**From:** Anita Gardner <Anita.Gardner@arun.gov.uk>  
**Sent:** 23 September 2019 12:57  
**To:** Planning.Responses <Planning.Responses@arun.gov.uk>  
**Subject:** FW: Application Ref: LU/164/19/PL - 5 Arundel Road, Littlehampton

**Environmental Health: Noise**

**Environmental Health:** I acknowledge information already provided in the Planning Statement, dated May 2019, Ref 13538. I now refer to that Noise Assessment, Job Number A113884, 3rd Issue, prepared by Wyg.

PROPOSED FLOOR PLAN 102.9 Sqm - 1107 Sqft GIA

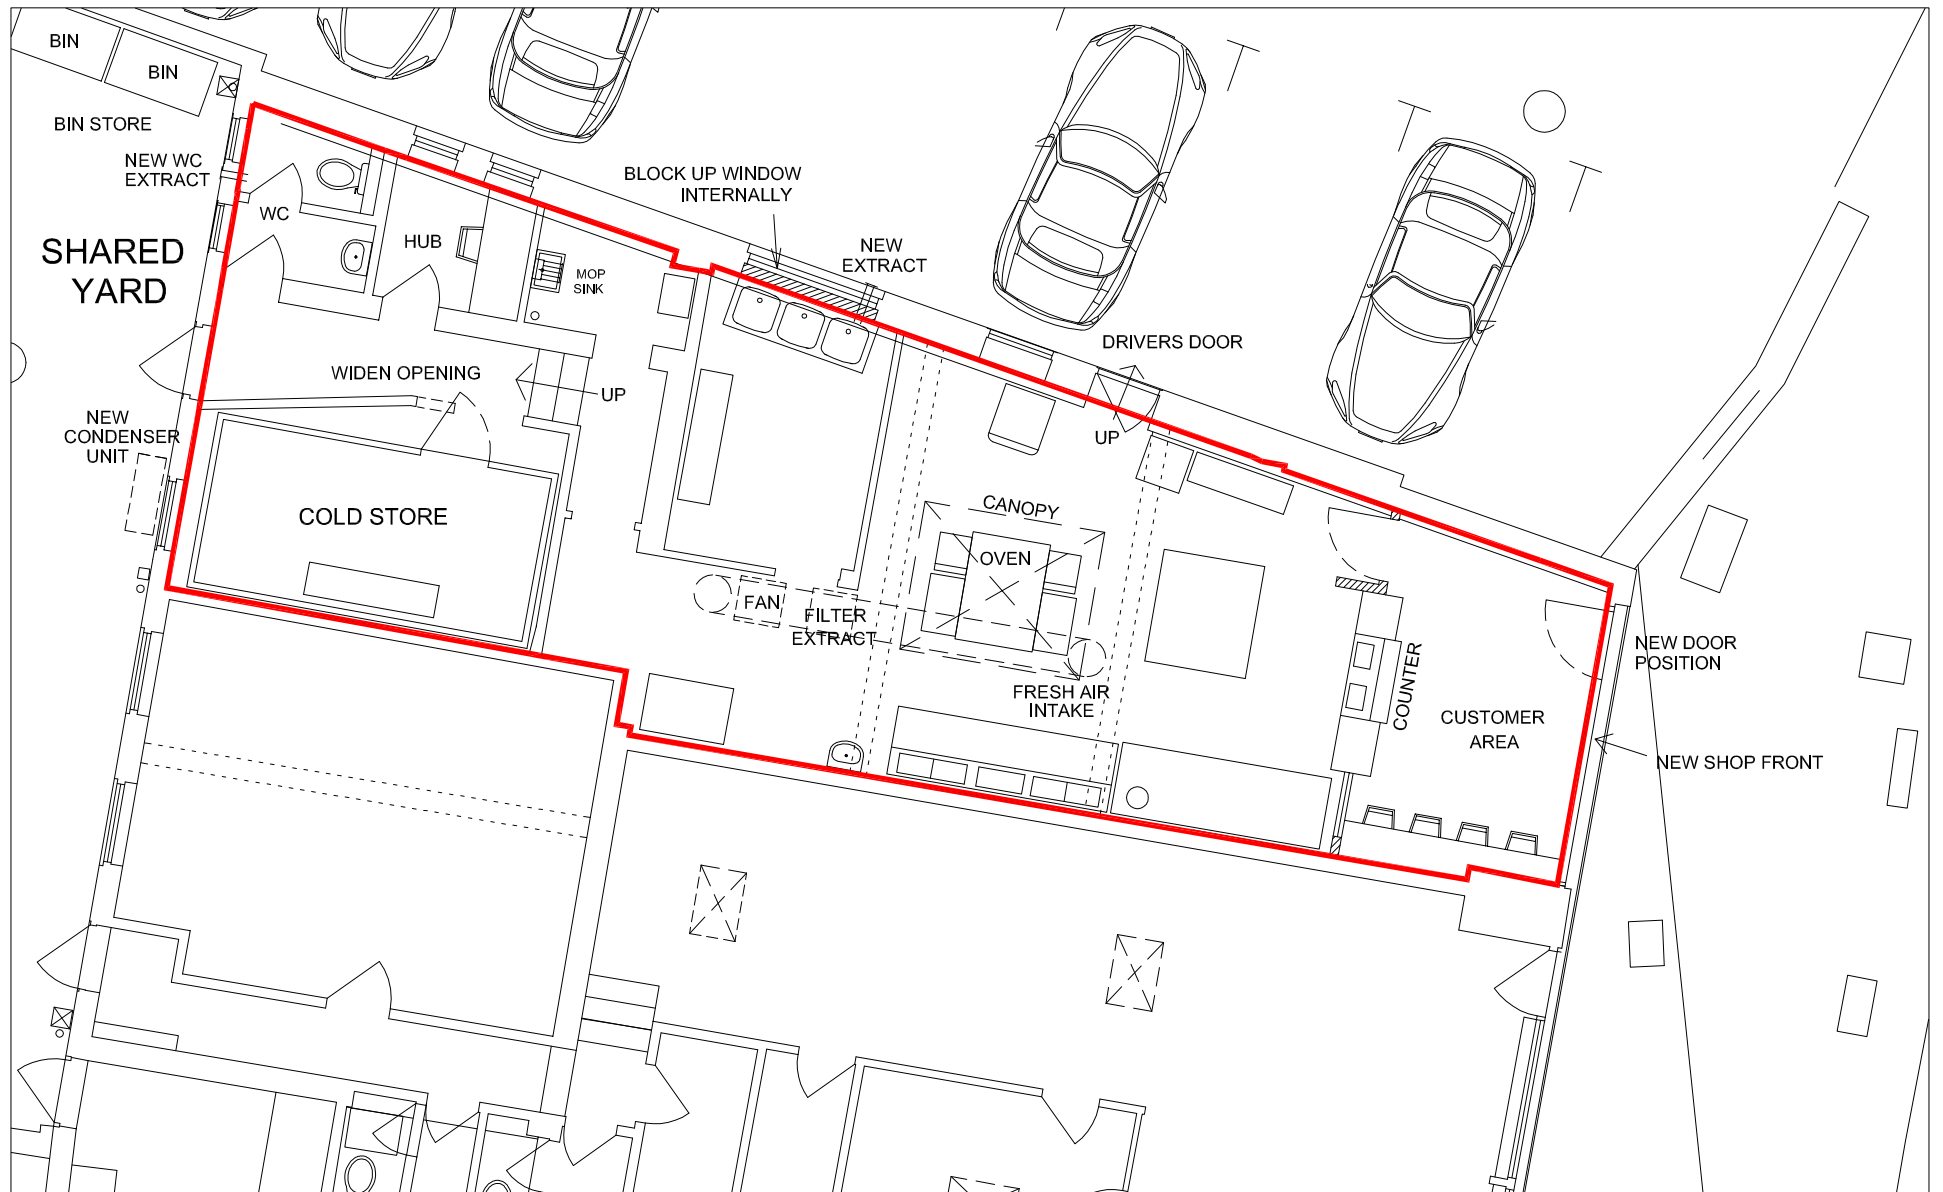
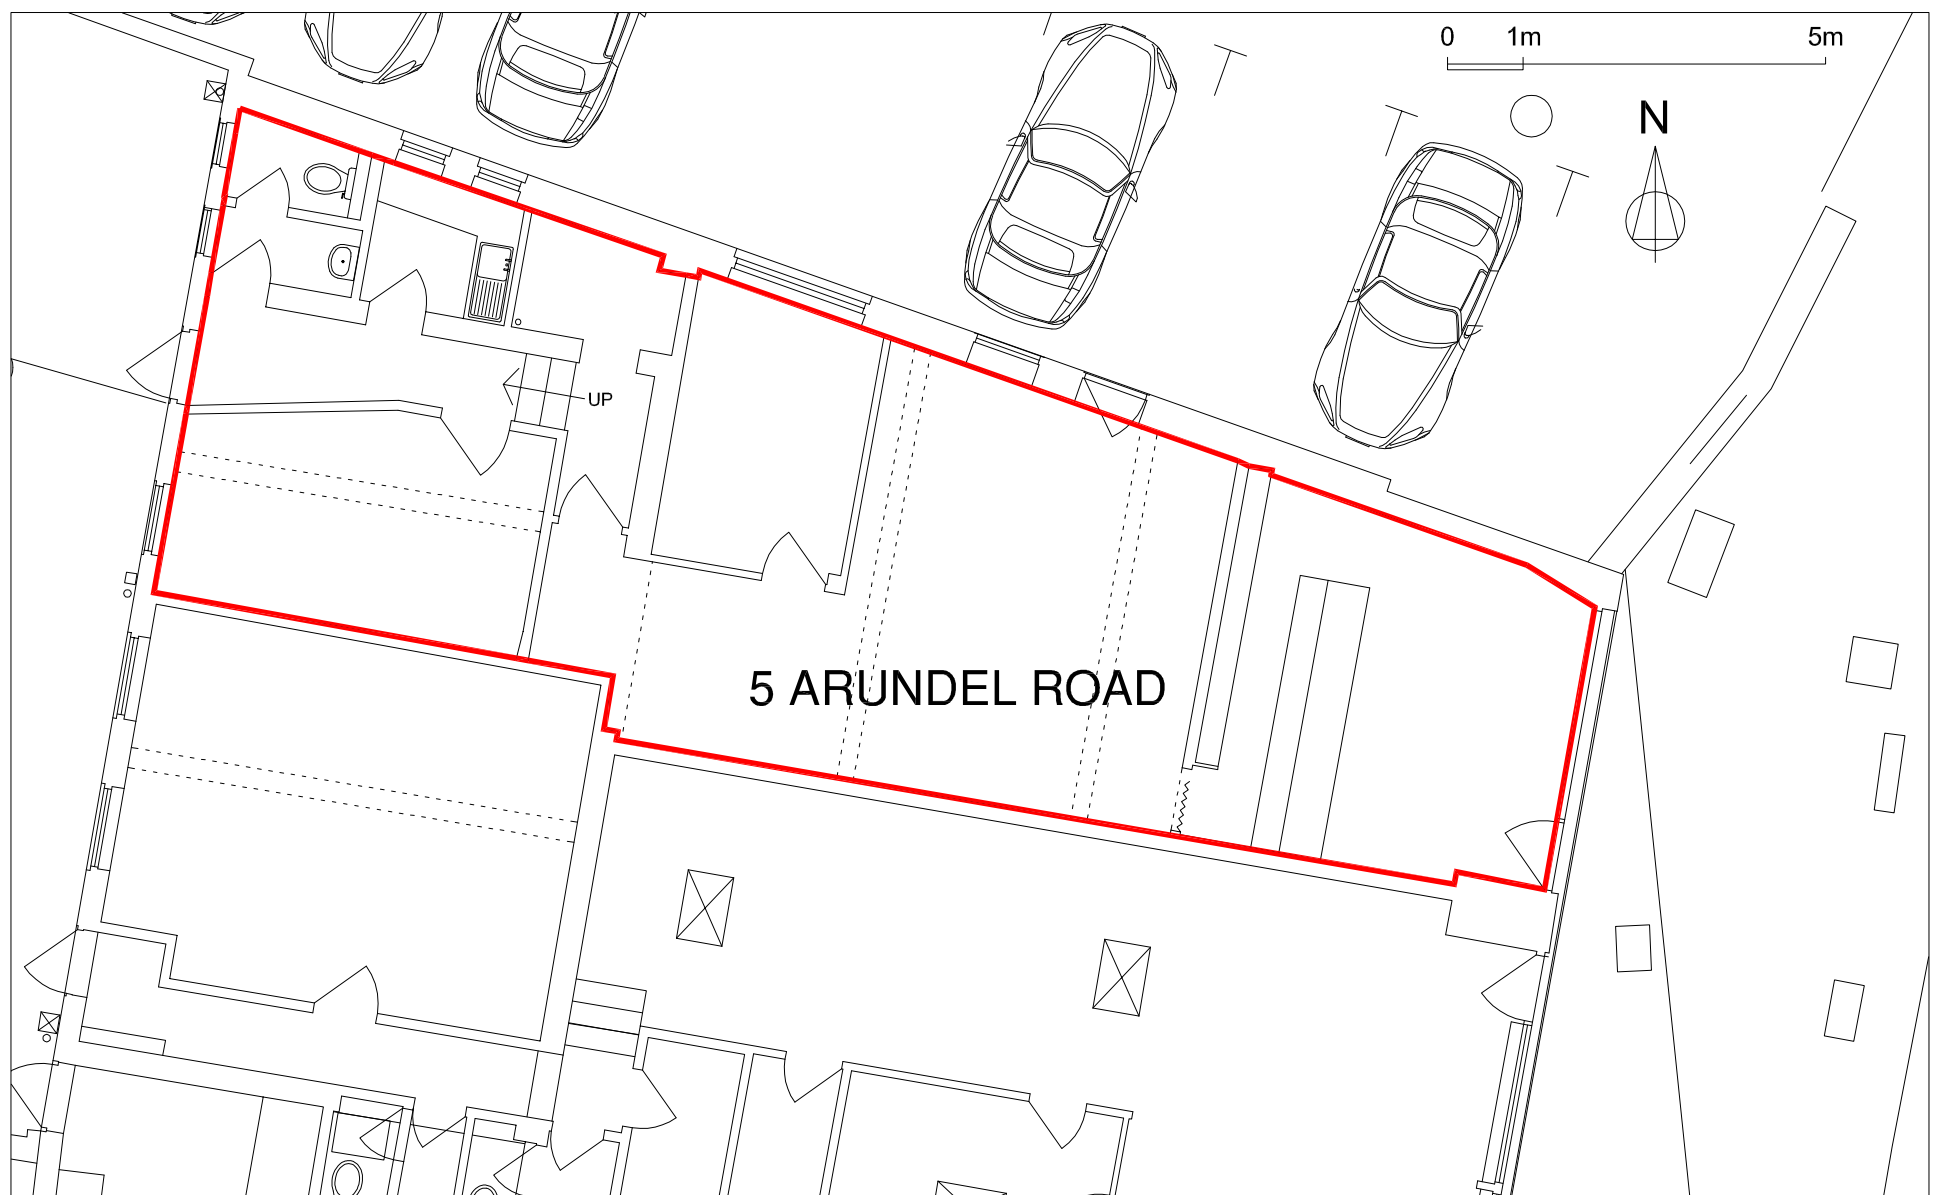
Please note that I am still not satisfied that the submitted internal layout is suitable in this case. Please do not hesitate to contact me again should I be able to provide any further assistance and please if you would, also copy all to Anita.

**Informative:** I await the applicant's response to my previous comment re kitchen layout and Wyg Odour Assessment, June 2019.

I would also concur that change to the internal layout of this food premises is unlikely to affect odour or noise output insofar as plant, equipment and mitigation measures already agreed are applied.

With regard to internal layout, our technical team has reviewed the plans and advised that alterations to the internal layout would not affect the odour outputs of the proposed development.
